Date: 04 August 2026

Order Granting Development Consent for Tween Bridge Solar Farm at land either side of the M180, High Level Banks (the A18) and the Stainforth and Keadby Canal (EN010148)

Deadline 5: Representations on further information submitted at Deadline 4

### Figure 2.5: Indicative Culverts Crossing Plan

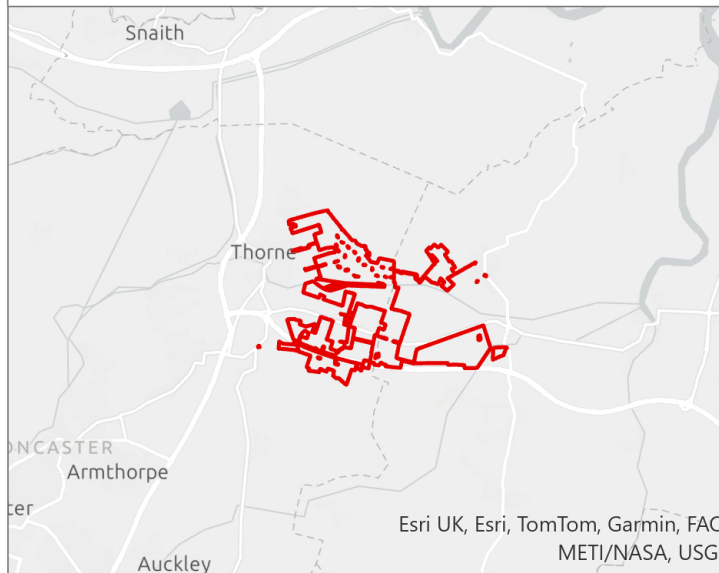
We welcome clarification under ref EN7 that it is not proposed to culvert the North Soak Drain. We support that the employment of clear span methods will be fully explored at the detailed design stage. We have no further comments to make on this matter and wish to reiterate that any culvert proposal will require consent under the Protective Provisions, as outlined in our Deadline 3 Written Representations [[REP3-076](#)].
